[EN020026-002378-SL 28JAN ISH2 PART3.pdf \(planninginspectorate.gov.uk\)](#)

Geraldine Barker from Saxmundham Town Council.

Design

Document 9.6.2 Appendix B: Consented SPR Outline Landscape Mitigation overlain with the Sea Link Outline Landscape Mitigation for NGET Substation (Scenario 1)

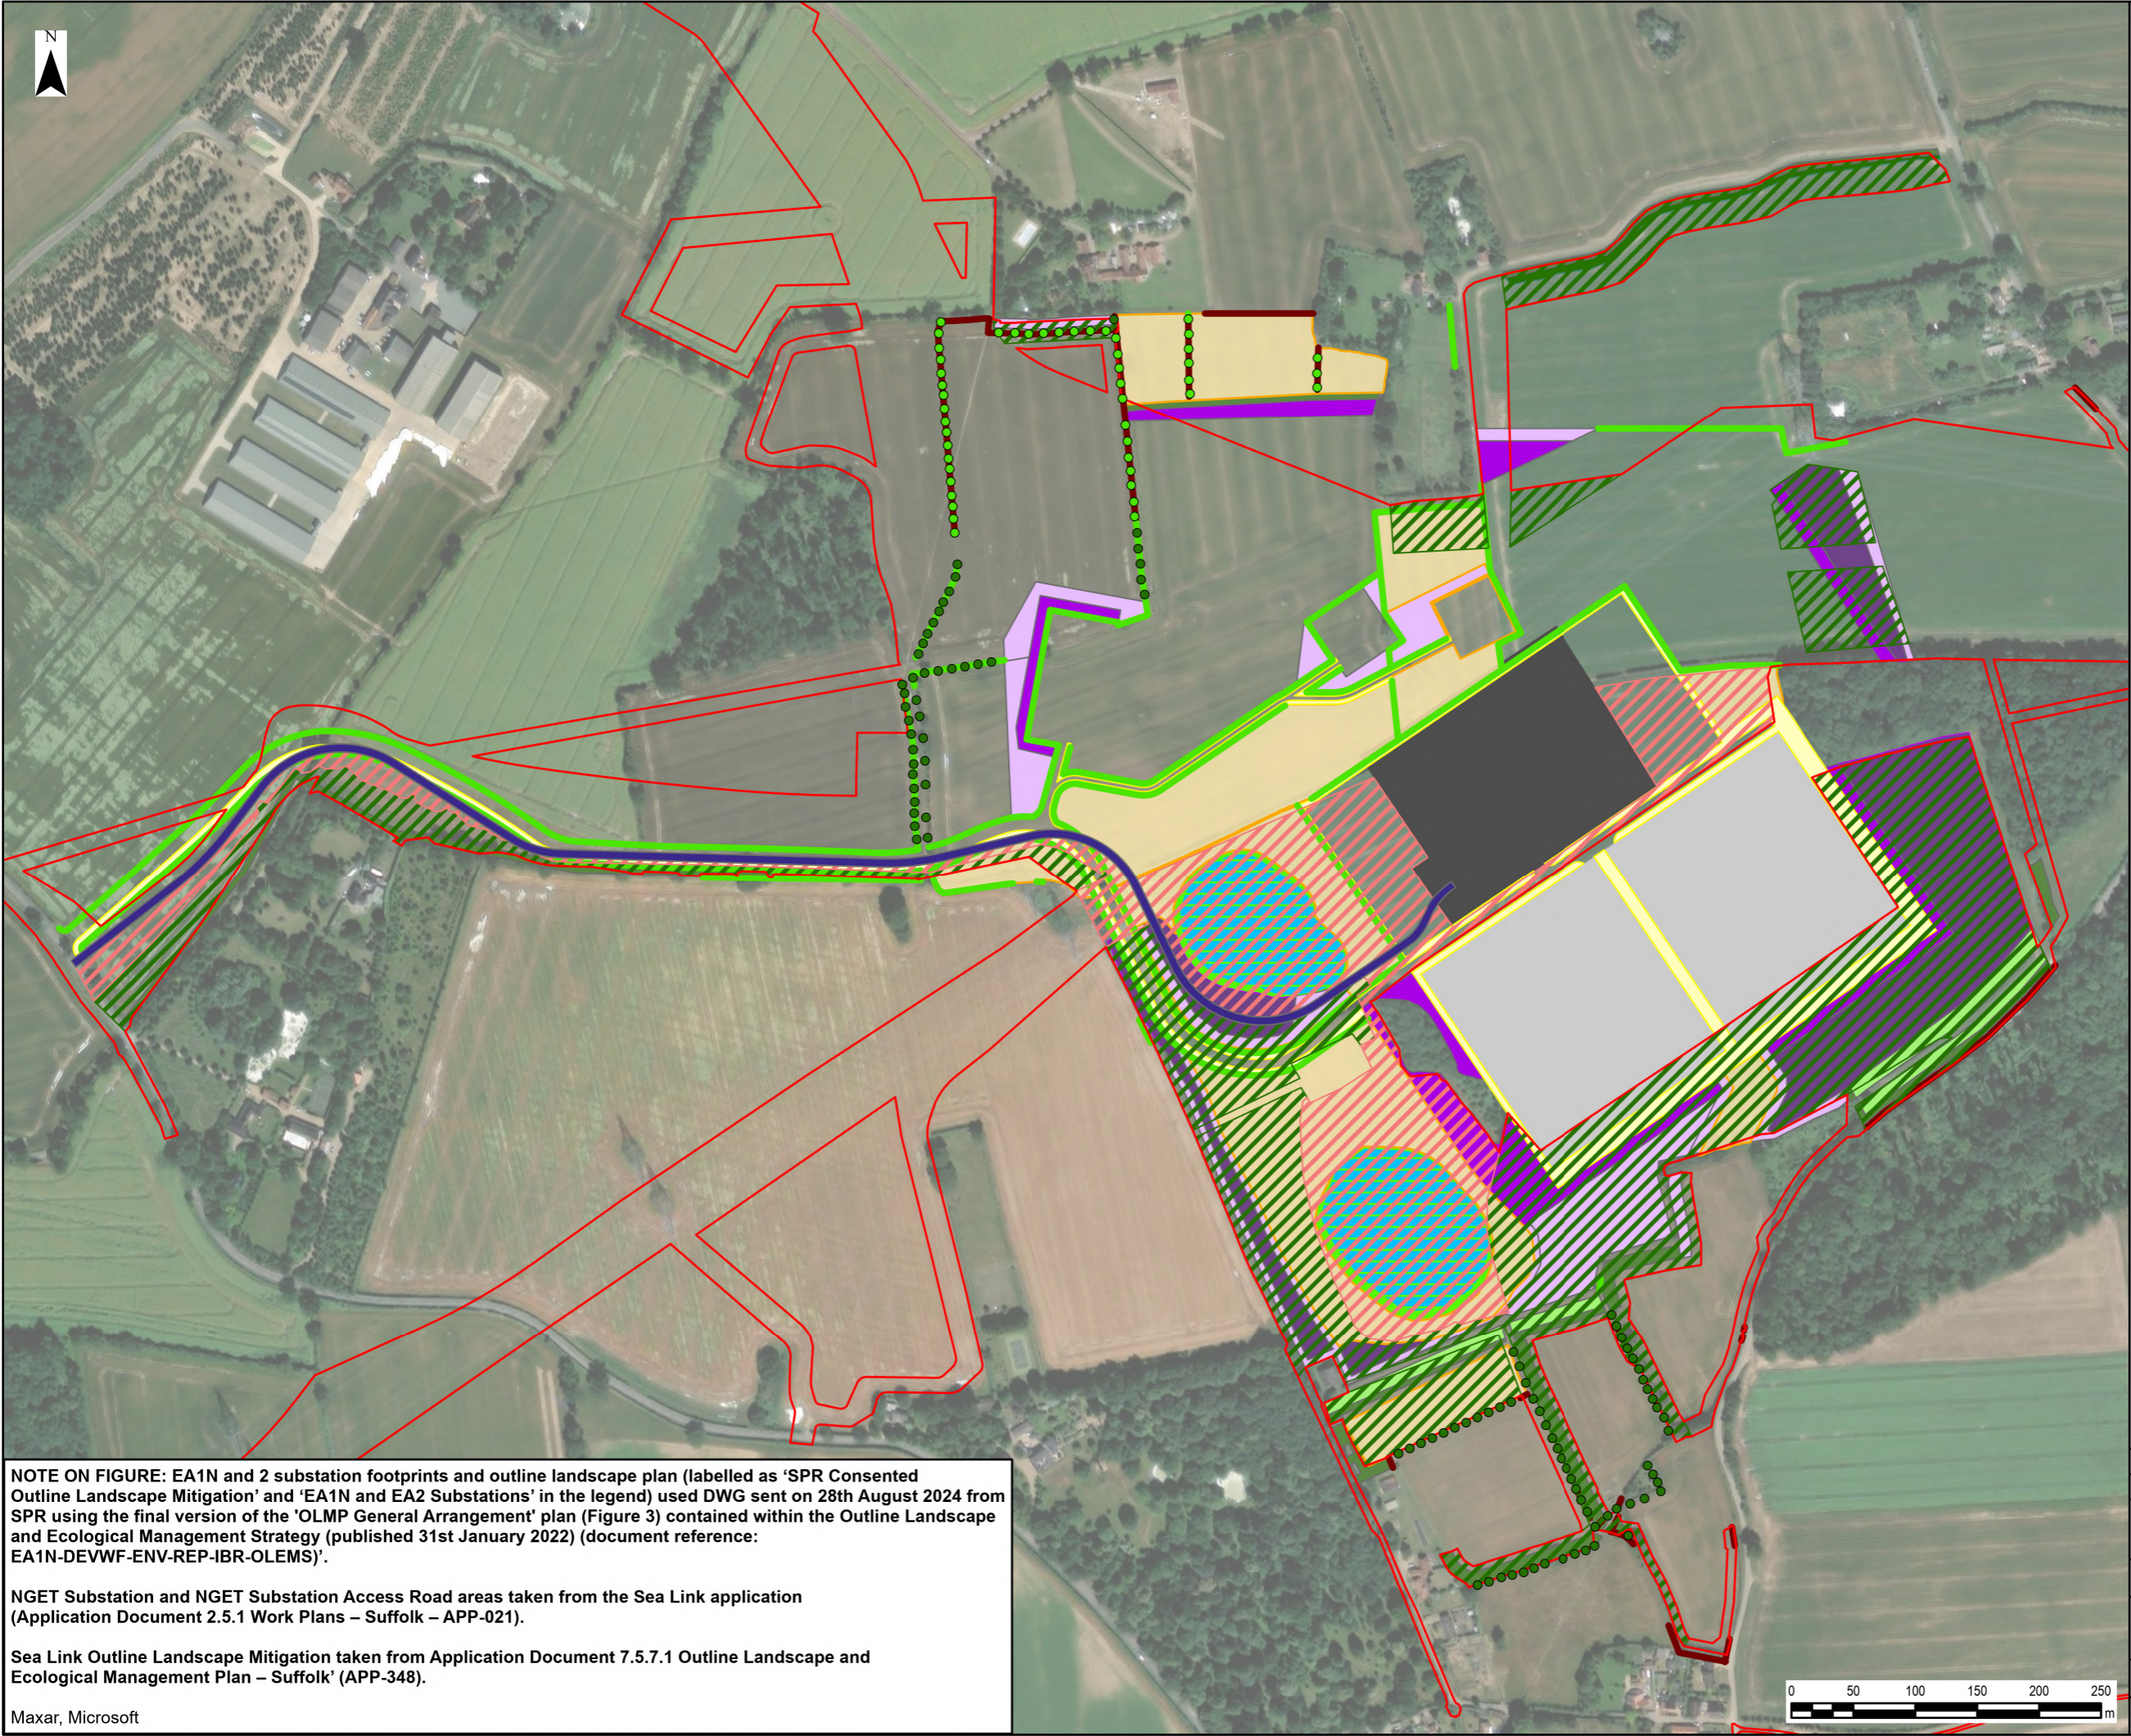
Landscape and Visual, in respect of planting to the right of the track that leads from the B1119 to Wood Farm.

The proposed Sea Link Converter on the landscape will be a blight on the landscape at this point. I asked why we couldn't have additional planting, and I believe this is intrinsically linked with the next proposed converter station, which is Lion Link, which I know it's outside the scope of this hearing. However, it is, it is very apparent from Lion Link's

The document, which I refer to, is Lion Link's potential design approaches. Lion Link appears to be taking on the majority of landscaping to both areas (Sea Link and the proposed Lion Link draft order areas) which will include extensive planting. Also Lion Link appears to propose to reinstate the Great Wood.

Finally, we would like to see planting around the B1119. Mitigation is not only required for PRoW users as consideration should be given to the visual implications for people entering Saxmundham by vehicle to negate the impressions of an industrialized landscape.

Document 9.6.3 Appendix C: Visualisations showing the indicative location of the Lionlink converter station alongside the Sea Link converter station

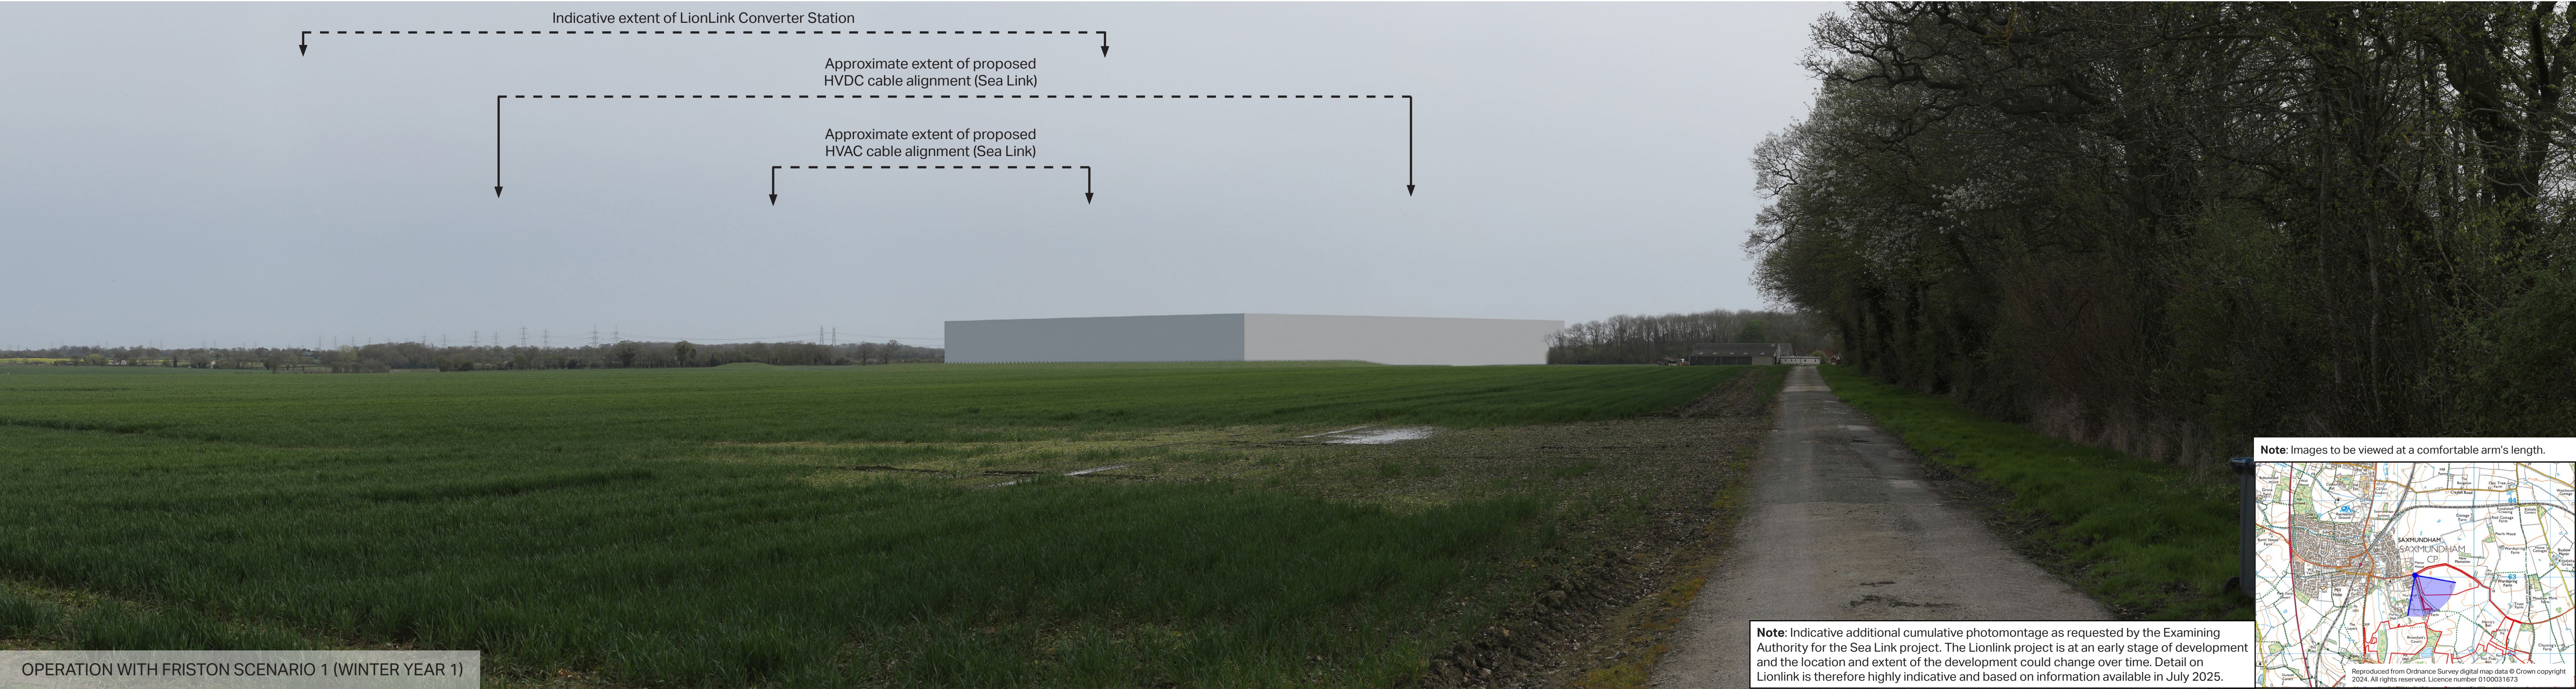
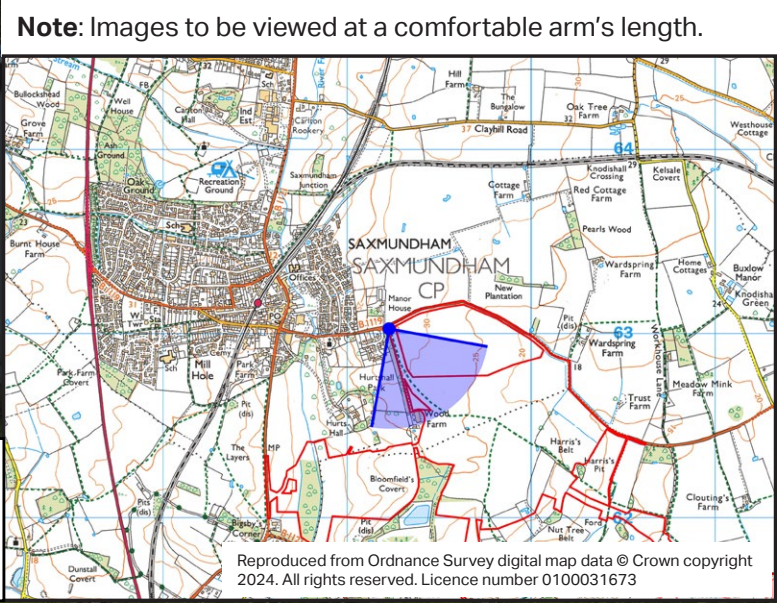
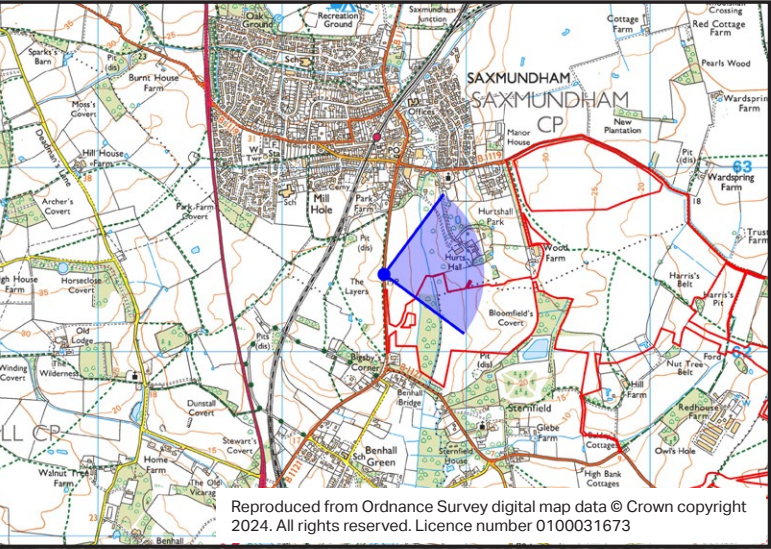
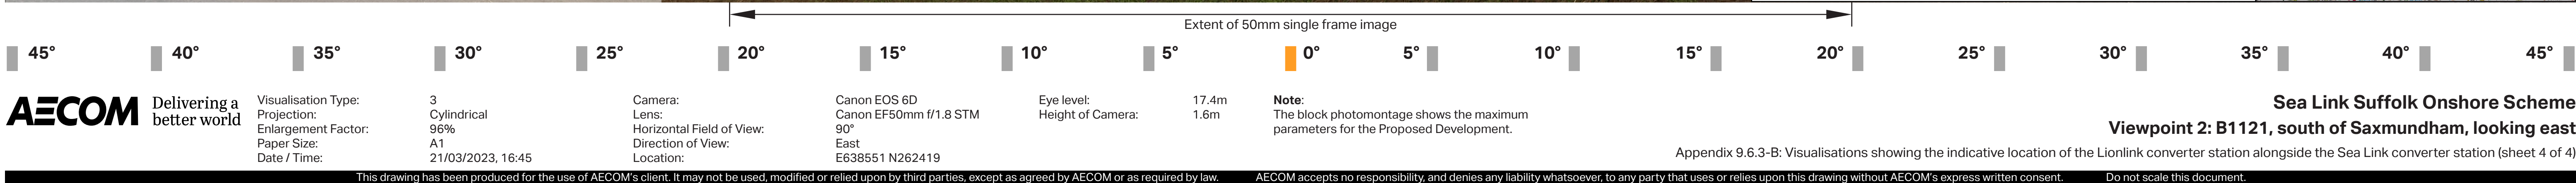
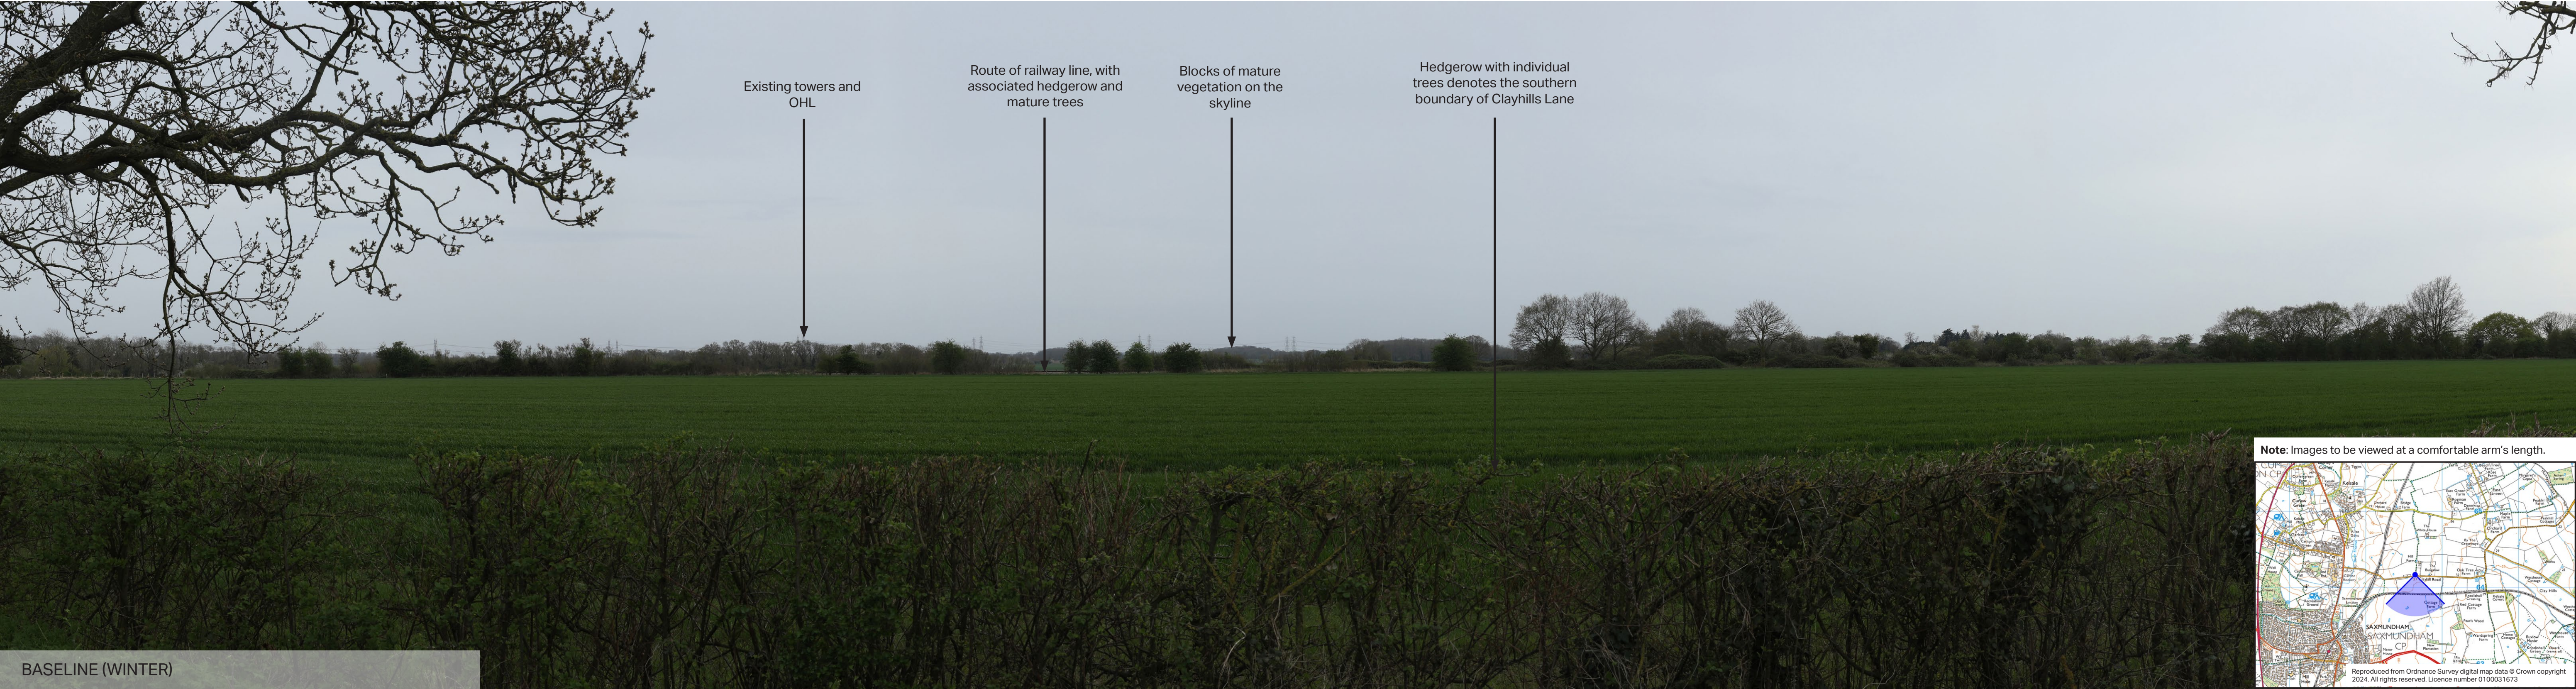
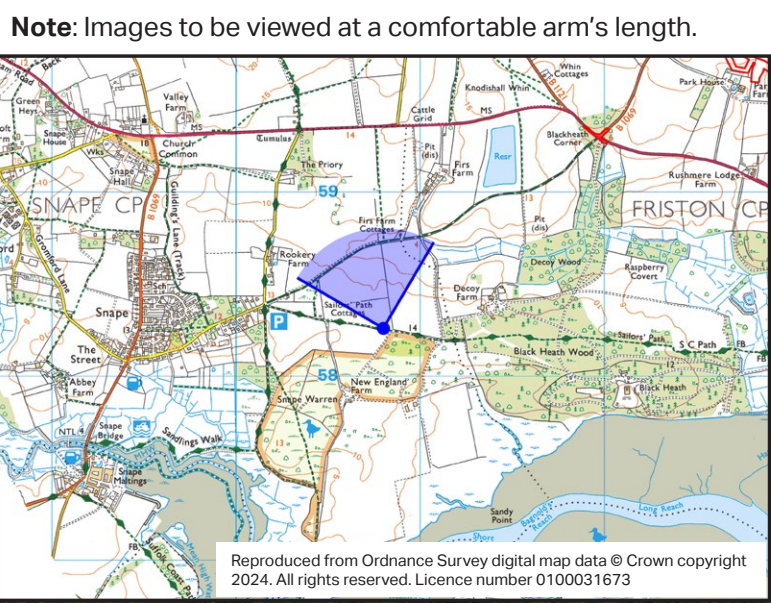
Lion Link's visualizations for the visual impact mitigation are superior to Sea Link. Moreover, they have proposed various different concepts for the exterior of the building.

I am wondering what is occurring, because the concepts that we have seen, albeit they are only concepts at the present time from Lion Link, seem to be far superior than Sea Link's designs. I'm very concerned, echoing Mr. Atkinson's views, that we have not been advised on the final converter design. This is very important for Saxmundham, for the villages, Sternfield and Benhall, that we get the best possible exterior design.
